Subject: Glenwood High School Upgrade (SSD 23512960)

Thank you for your email received 17 November 2021 requesting comments on the Environmental Impact Statement (EIS) for the subject proposal. The Environment, Energy and Science Group (EES) has undertaken a review of the EIS and related information and provides the following comments.

Susan Harrison
Senior Team Leader Planning
Greater Sydney Branch
Biodiversity and Conservation

Figure 34 | Proposed tree removal (Base Source: Applicant's Revised AIA, 2022)

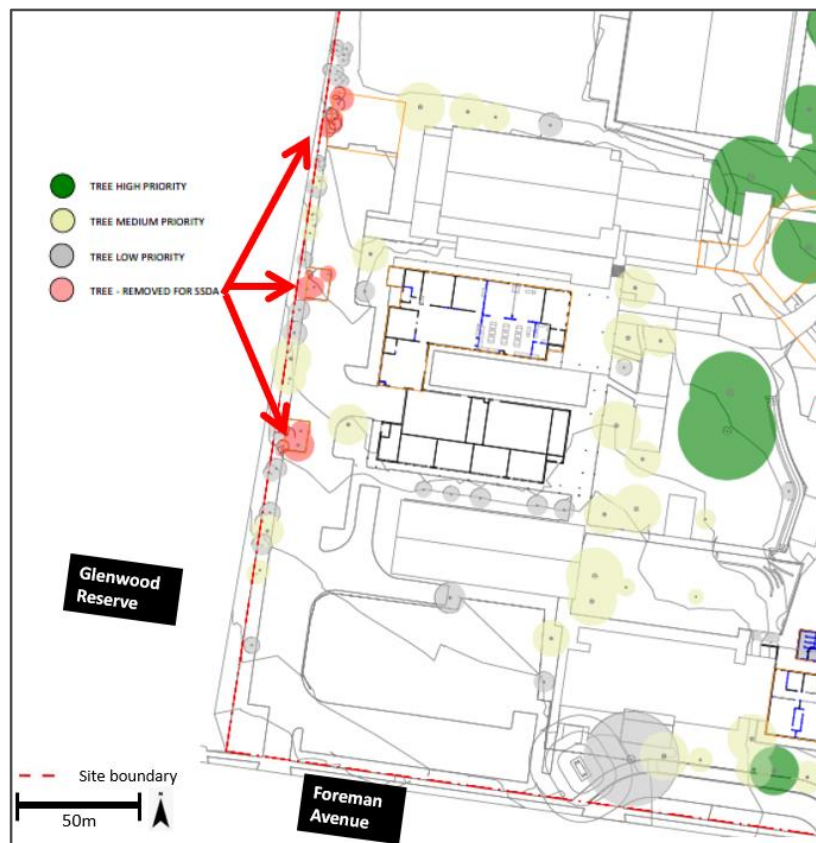
- The report states that *'one high retention value tree (Tree 73) will be subject to high Impact from SSD works. There may be possibility for design changes which could allow for the retention of this tree however the current design does not allow this tree to be retained.'* EES notes that the actual level of encroachment into the tree protection zone (TPZ) of the tree has not been documented in the report, however if there is potential for this tree to be retained and protected, this should be further explored.

- A major encroachment into the TPZ of Tree 72 is also proposed under the subject SSD. The exact extent of encroachment is unclear however the report notes the tree may be retained subject to specific construction methodologies and timing of works. Further clarity should be provided regarding the actual measures required to retain and protect this tree.
